WELWYN HATFIELD BOROUGH COUNCIL – DEVELOPMENT MANAGEMENT
DELEGATED REPORT

APPLICATION No: N6/2013/2449/FP

SITE ADDRESS: 77 Eddington Crescent, Welwyn Garden City

DESCRIPTION OF DEVELOPMENT: Erection of single storey and two storey rear extension

Drawing Title: PLANS AND ELEVATIONS  
AS PROPOSED

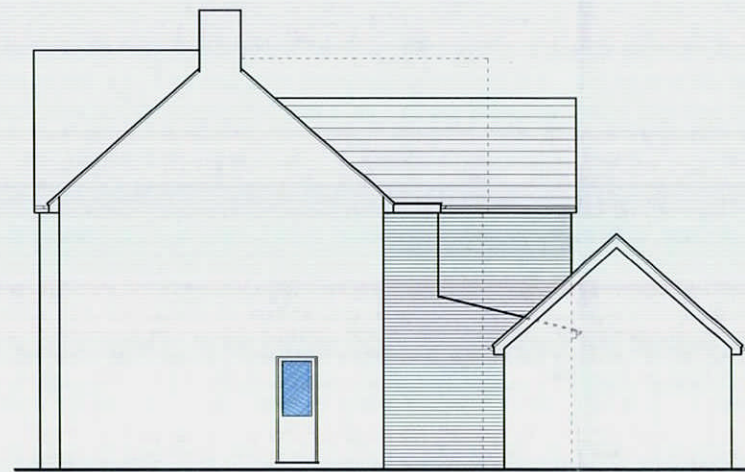
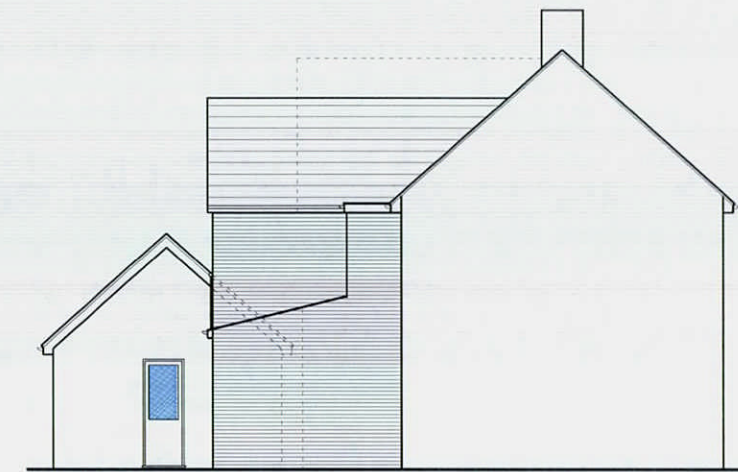
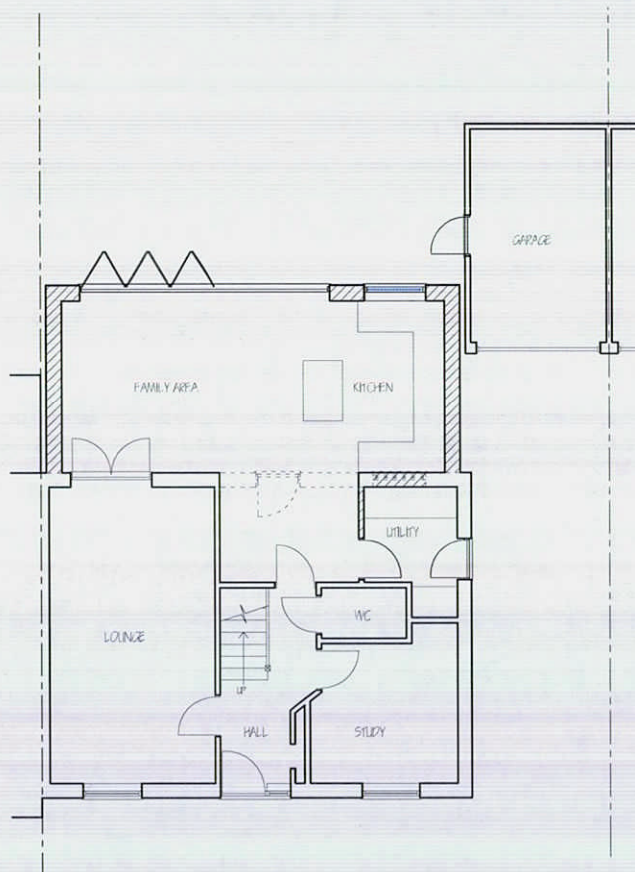
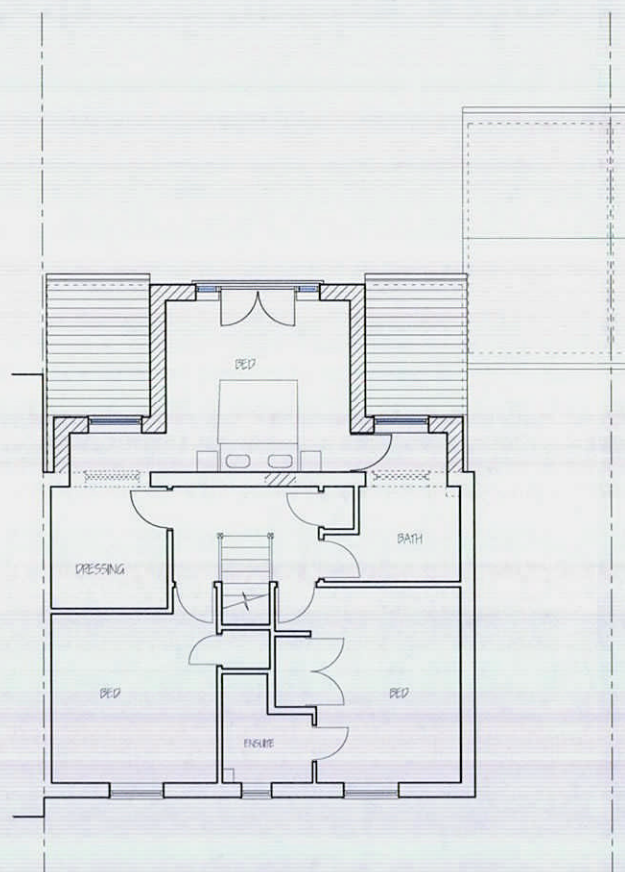
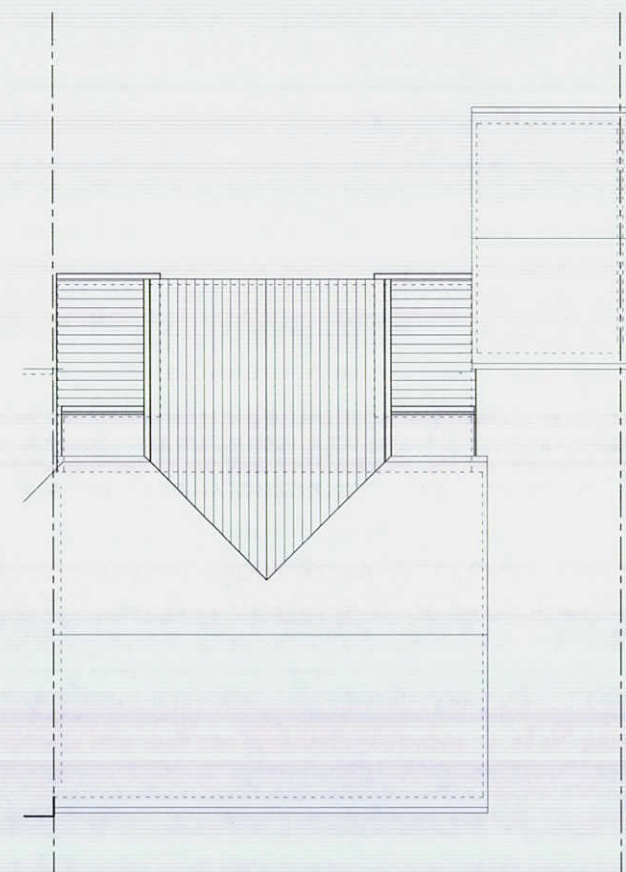
The existing house occupies a footprint of approximately 6.2m deep and 8.4m wide, across two storeys. At ground floor level the footprint of the proposed rear extension would be approximately the same width as the house (8m) and about 3.6m deep. A second floor would sit above to the same depth, across about half (4.2m) of its width, centrally sited on the rear elevation so that about 2m of single storey element, with a lean-to roof, would sit below on either side. This element would feature a gable with pitched roof with ridge height about 1m lower than that of the main dwelling house. It would have a centrally positioned door and Juliet balcony, sited above wider folding doors on the ground floor below, oriented towards the rear garden as per the existing rear elevation fenestration on both floors.

This proposal follows a previous proposal which was for a two storey rear extension of approximately 50% wider design, where the resultant mass, bulk, scale and design, would fail to be subordinate to the original dwelling house and would result in a dominant form of development which would not represent high quality design and would fail to be compatible with the maintenance and enhancement of the character and appearance of the area, contrary to the above policy requirements. It featured an awkward flat roof join with the first floor of No 75 to the east and its roof design was dominant, failing to sit as a subordinate extension to the host property. This proposal has reduced the mass and bulk of extension considerably through the use of a smaller extension of about 50% less width at first floor level. In doing so, this has

reduced its required scale at its gable pitch, with the resultant extension and its ridge sitting about 1m below that of the main dwelling house. Its central siting, with single storey element at either side, and removal of a two storey element adjoining No.75 assists in reducing the visual dominance of the extension and removes the need for a first floor flat roof join with No.75 as found in the previous application which was considered poor quality design in the report for that proposal.

With reference to that aspect, the report for the previous proposal specifically cited the incoherent roof approach with a flat roof element between the existing gable at No.75 and proposal gable, along with the flat roof join with No.75 emphasising the bulk of second floor element being proposed between the two storey gable proposed and the second floor of No.75 as reasons for the poor quality design. It said that a single storey element at the join with No.75 would enable a roof form to be possible which sits subservient to that of the main house. This proposal has taken on board these concerns by removing the need for a second floor at this element adjoining No.75, and through the use of a lean-to sloped roof here, which matches the sloped character of the main house roof.

Whilst folding doors/a large area of glazing would feature on the ground floor, and a door instead of window, with associated Juliet balcony, would feature at first floor level, it is noted that whilst this would be visible from the public right of way to the rear, these features would nonetheless not be visible from the primary street scene of Eddington Crescent. Given their siting and limited size in the context of the wider house, they are considered capable of incorporation here without jeopardising the

With regard to overlooking and loss of privacy to either adjacent property, it is noted that no side elevation windows are proposed on the ground or first floor of the proposed works;

At first floor level, the proposal seeks a centrally positioned door and Juliet balcony on the rear elevation. The house currently features bedroom windows on the first floor rear elevation which afford opportunities for (oblique) overlooking of the rear garden to either adjacent property. The garage has a pitched roof which extends to a height close to the first floor eaves height of the main house. Due to the depth of the extension, the Juliet balcony would sit adjacent to this approximate area, where the bulk of the garage and its width from the balcony side to its far side boundary with No.75 would prevent direct overlooking and loss of privacy to the rear elevation and
